M25 junction 10/A3 Wisley interchange

TR010030

9.60 Response to Surrey County Council's Deadline 4 letter

March 2020

Figure 4.1 Composition of traffic on B2215 Portsmouth Road (north)

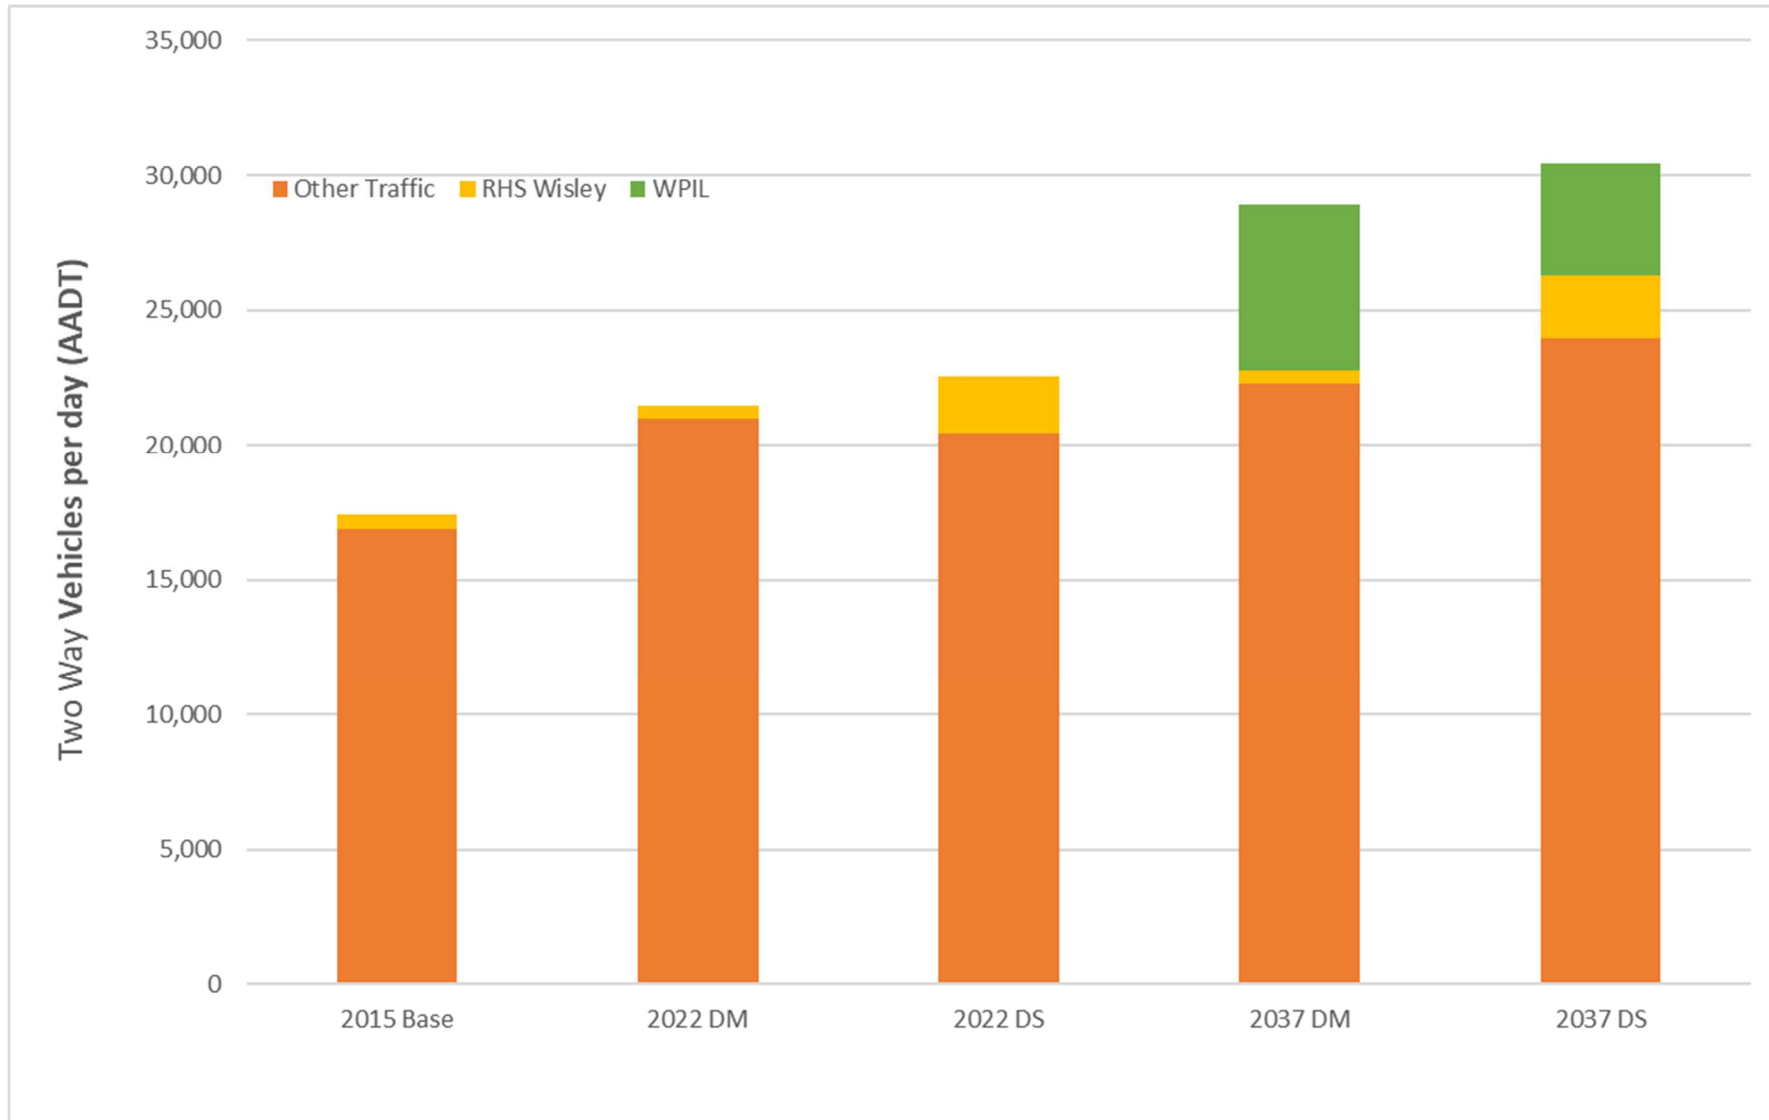
| Point Reference | Highways England's comment on LIR | Surrey CC's comment | Highways England Response |
|-----------------|--|--|---|
| 7.2.1.20 | <p>SCC has acknowledged in a meeting with Highways England held on 11 December 2019 that the measures requested and set out in paragraph 7.2.1.20 of the LIR would not have the effect of reducing traffic flows through Ripley.</p> | <p>This is not a statement that SCC made at this meeting, neither is it referenced in the draft HE traffic modelling meeting minutes held on 11th December and shared with SCC on 6th February (yet to be agreed by SCC). The County Council stands by comments made within the LIR in relation to mitigation requirements for Ripley. As stated, the measures are also intended to slow traffic speeds through Ripley to encourage more RHS Ripley end general Wisley Lane traffic to use Highway England's signed 'u' turn route through the M25 J10 roundabout. SCC consider that a threshold of +30% for severance is too blunt a measure to determine whether mitigation is required. It has to depend on the circumstances of where the increase is occurring</p> | <p>Highways England withdraws the statement that "SCC has acknowledged... that the measures requested in paragraph 7.2.1.20 would not have the effect of reducing traffic flows through Ripley", and notes this as errata in the Applicant's comments on the Joint LIR document [REP3-007].</p> <p>However, the Applicant maintains that some of the mitigation measures proposed by SCC, e.g. resurfacing, will not have the effect of reducing traffic flows through Ripley</p> <p>The threshold of +30% additional traffic flow is derived from guidance contained in Guidelines for the Environmental Assessment of Road Traffic - Institute of Environmental Assessment 1993 and is a suggested threshold for minor severance effects, with 60% increase for moderate effects and 90% for major effects. This is still considered to be standard practice in consideration of severance effects.</p> |
